Application No: FP/78/14/PL

Recommendation Report for Planning Permission

LOCATION: 63 Outerwyke Road
Felpham

PROPOSAL: Re-positioning of boundary wall with intermittent fence panels

sheet 1 of 2

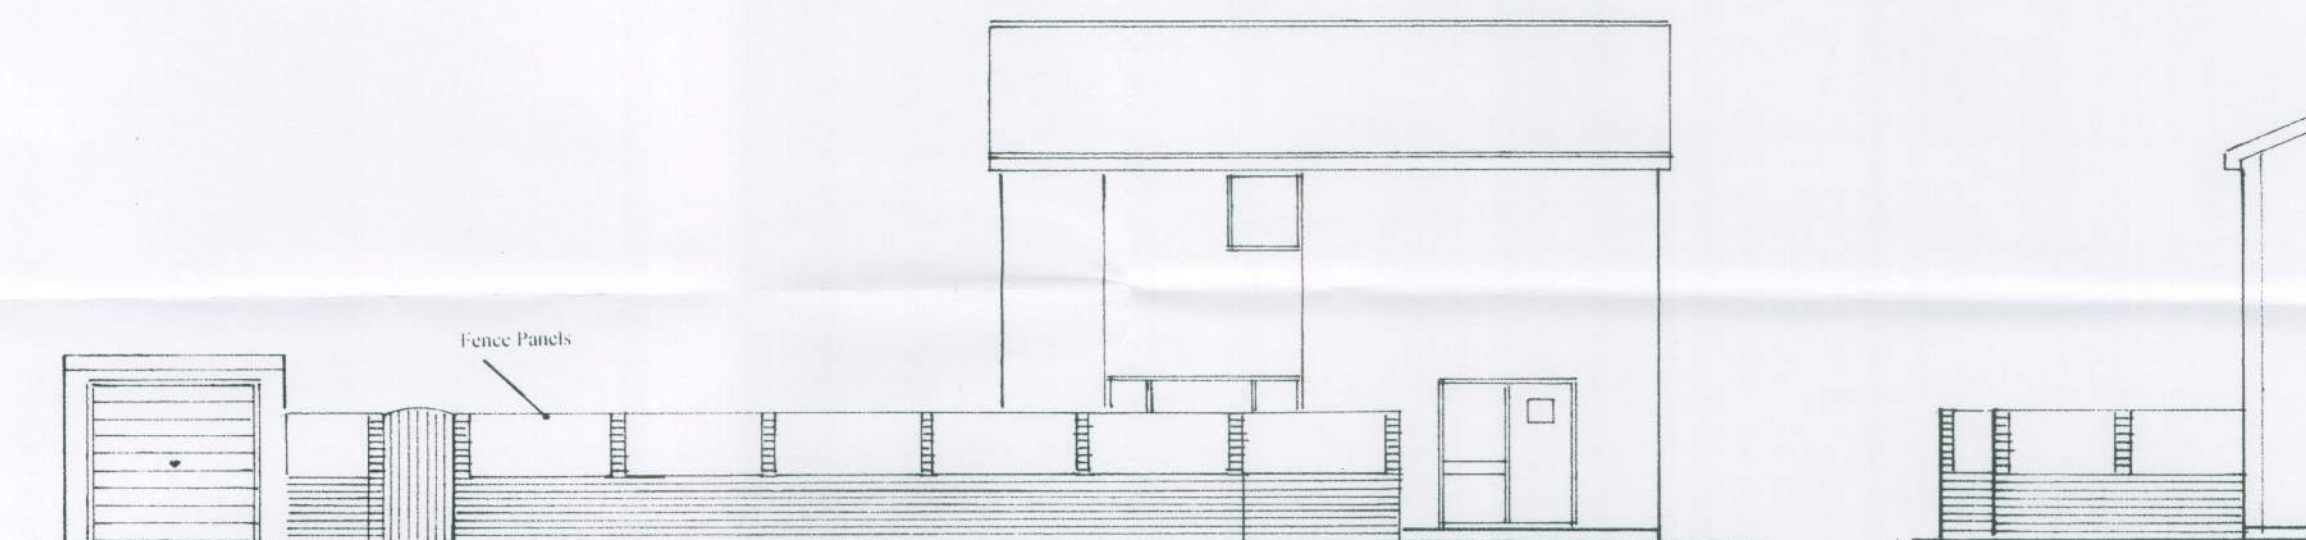
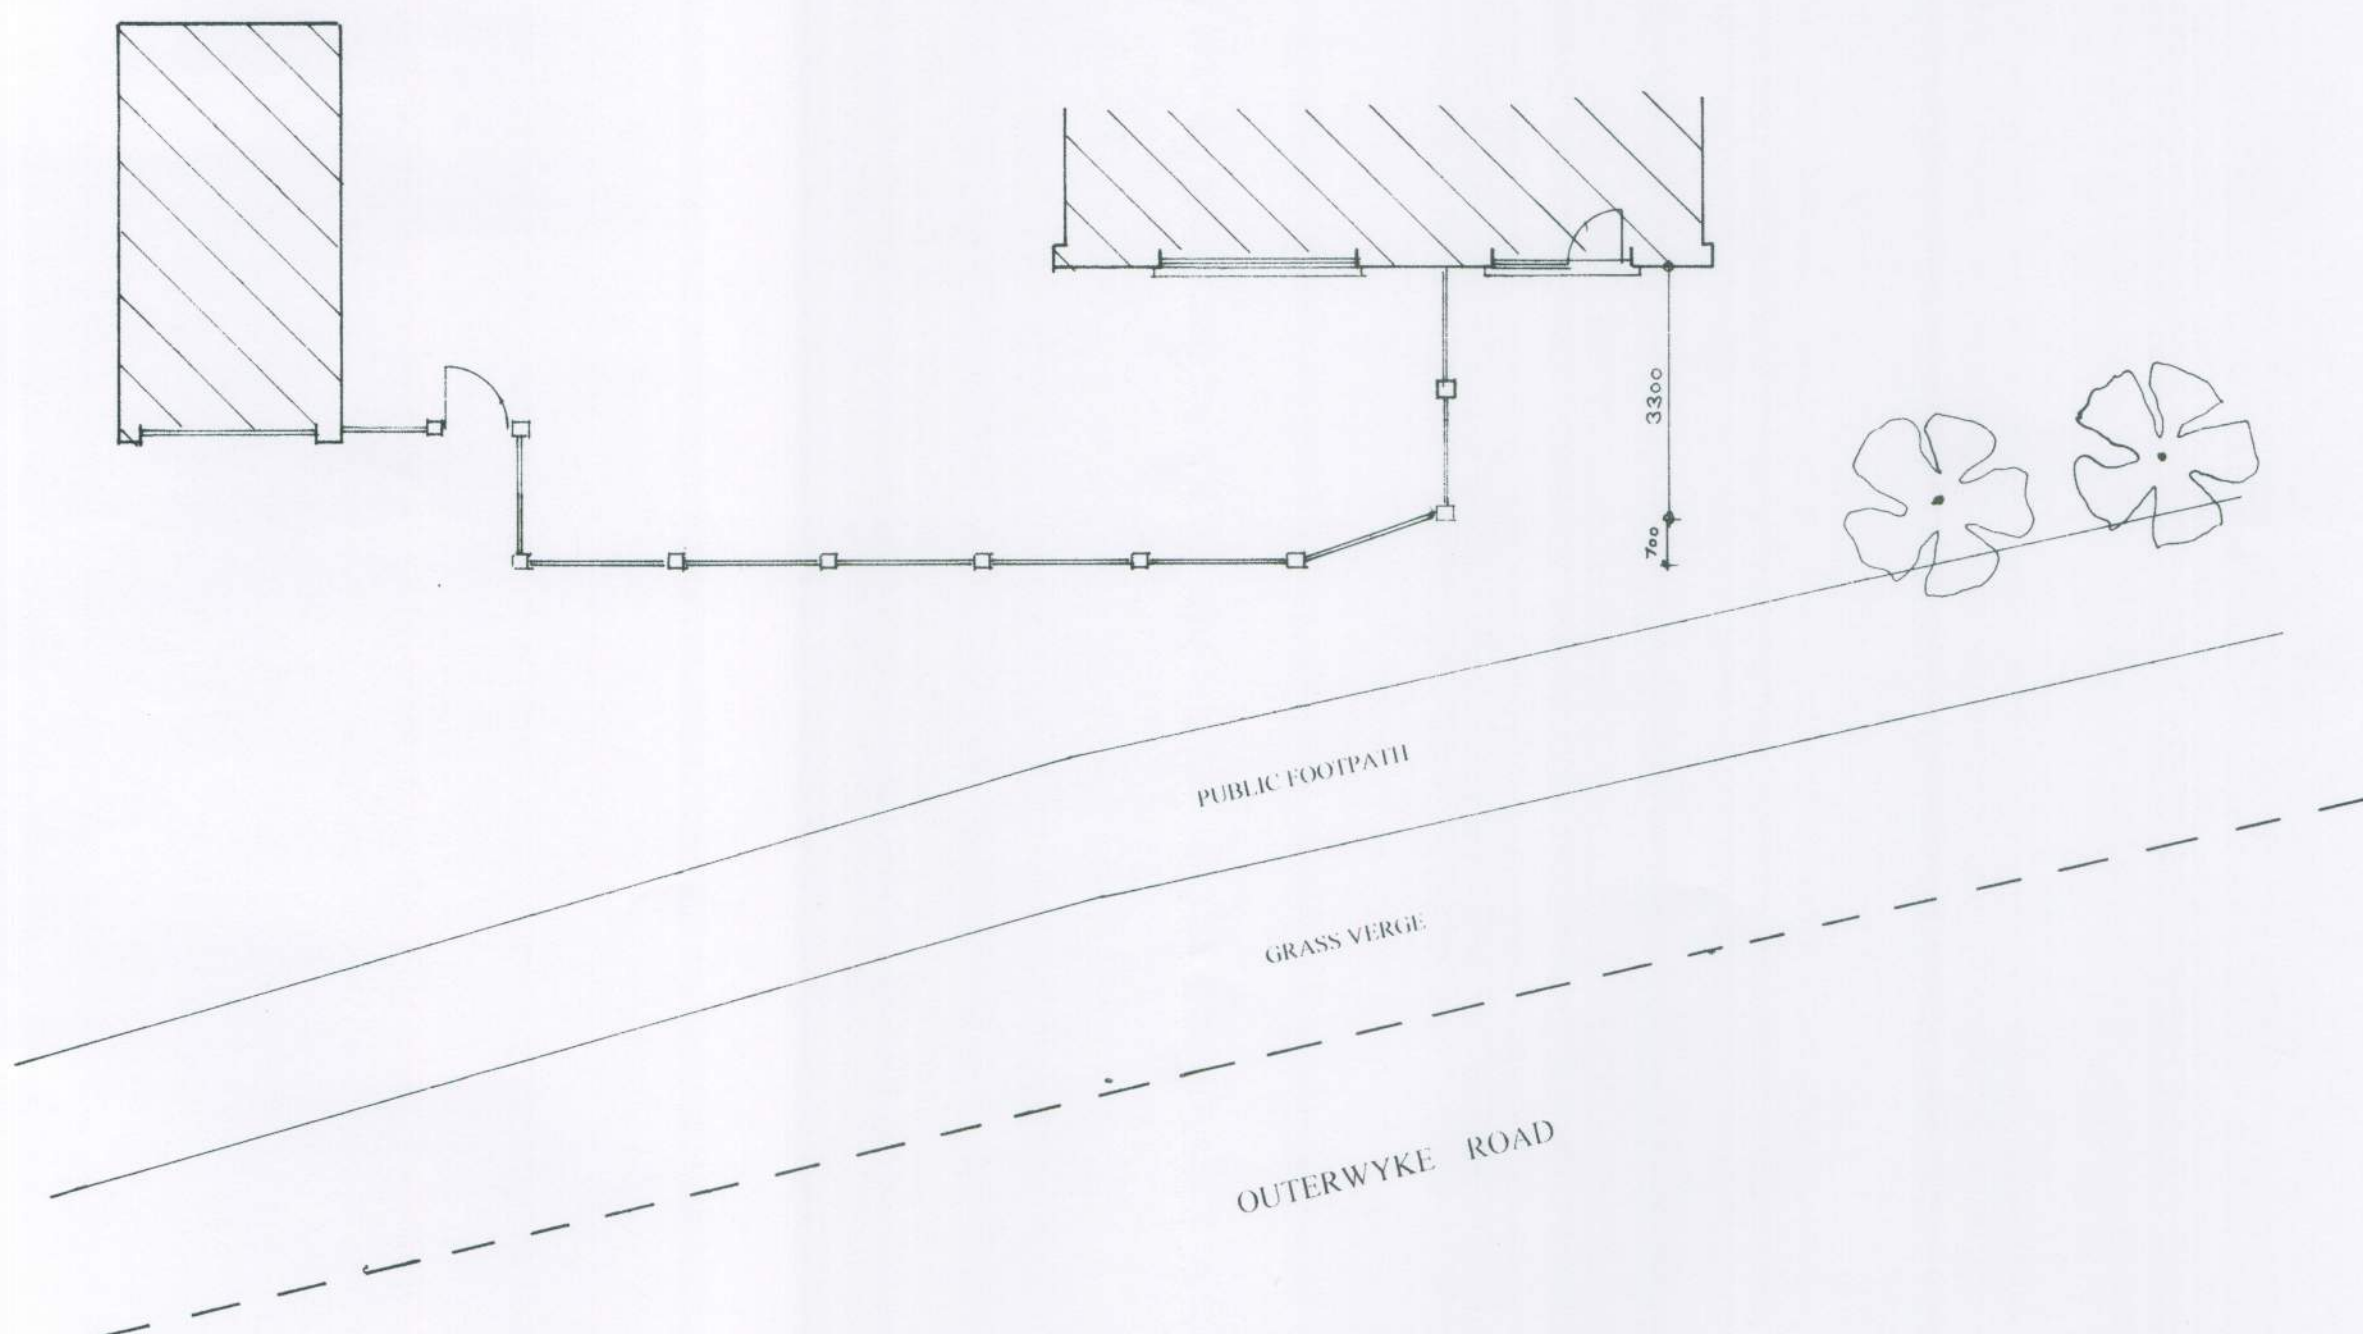
The existing wall which is 1.8m in height extends along the southern side boundary to the detached garage to the rear. The existing wall is set back from the public walkway by 3m-7m with an open area which is partly grassed with gravel. The proposed wall which will be constructed of brick to match the host dwelling will have fence panels positioned within brickwork piers with a

new pedestrian gate sited to the western end by the garage. The proposed wall will be repositioned closer to the public walkway leaving an open area of between 2m-4m.

In view of the fact that the repositioned wall does not enclose all of the open land and a significant buffer will remain open the proposal would not conflict with the aims of Policy GEN7 of the Arun District Local Plan.

- 2 The development hereby approved shall be carried out in accordance with the following approved plans: Location 1:1250, Block 1:500, Proposed Elevations Sheet 1 of 2 received on 2nd June 2014.

- 3 The proposed brick wall hereby permitted shall match in colour and texture those of the host dwelling.
